**WEST SUSSEX COUNTY COUNCIL
STRATEGIC PLANNING CONSULTATION**

SUBJECT: BE/63/14

Installation of Solar Farm comprising erection of solar arrays, inverters, transformers, equipment housing, security fencing, internal tracks & ancillary equipment. Departure from the Development Plan.

Manor Farm, Shripney Lane, Shripney, West Sussex, PO22 9UR

Existing Site Access

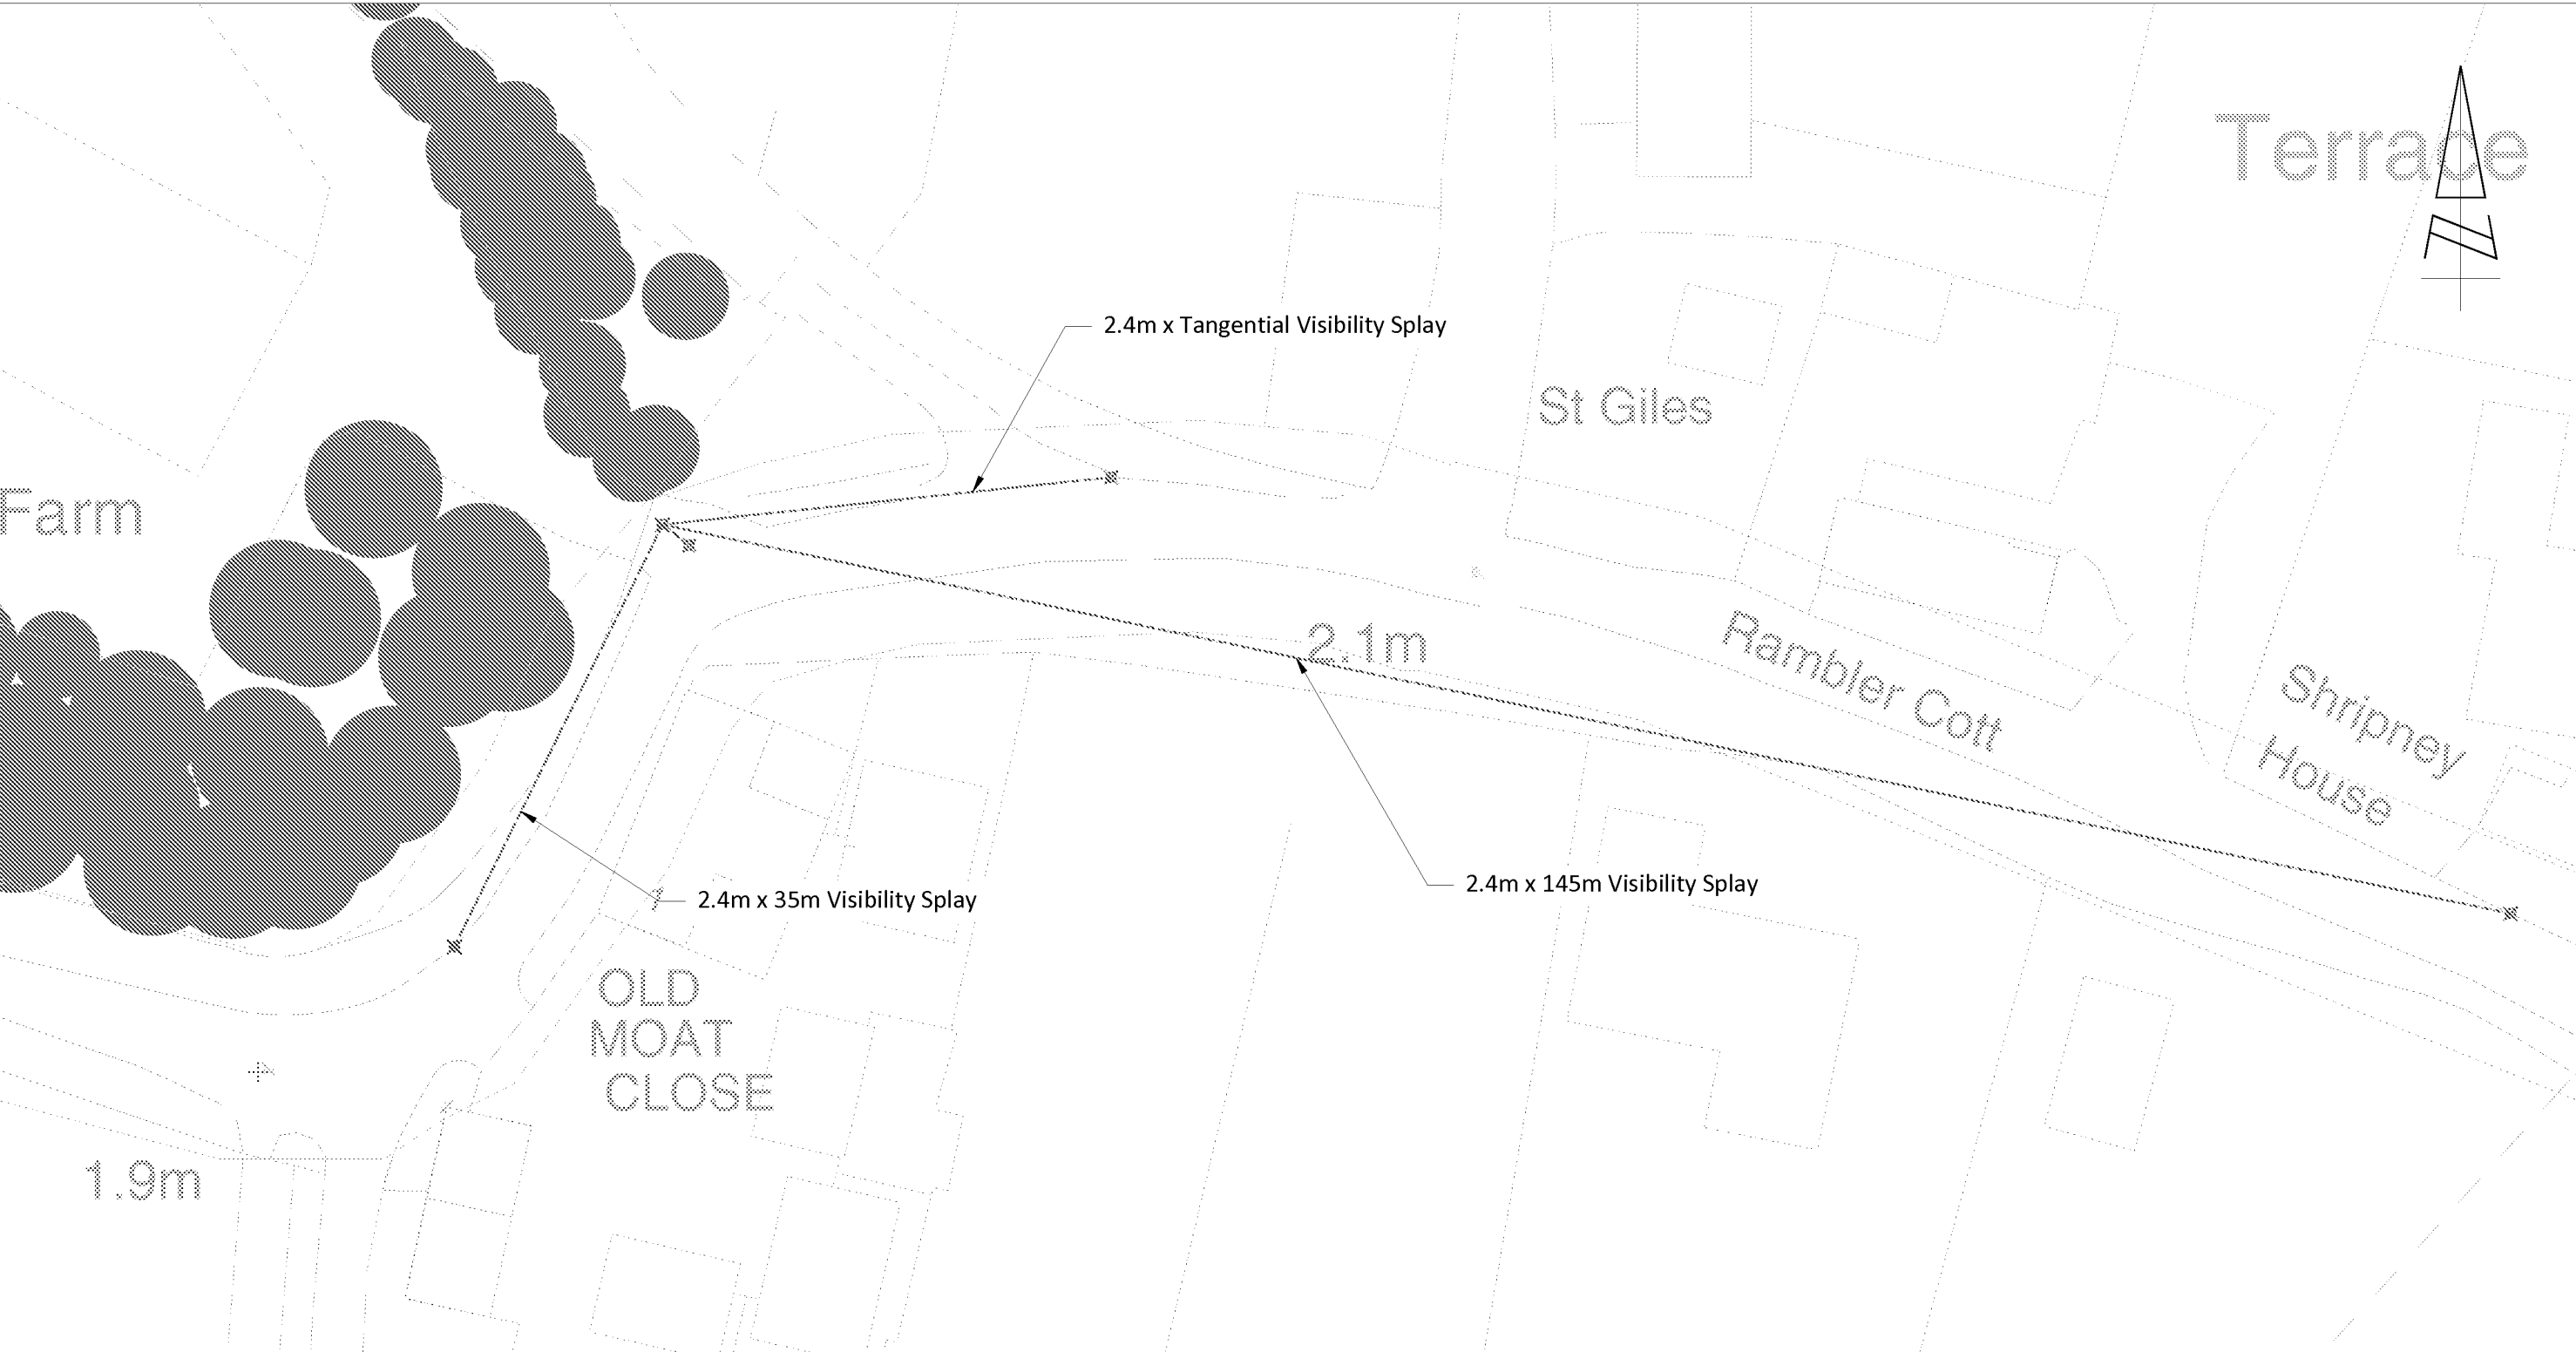
The Applicant has demonstrated that the junction of Shripney Lane and the A29 provides adequate access for low loader articulated vehicles, which will be the largest vehicle to access the site. Similarly, vehicle access from Shipney lane is adequate and suitable visibility can be achieved for vehicles exiting the site.
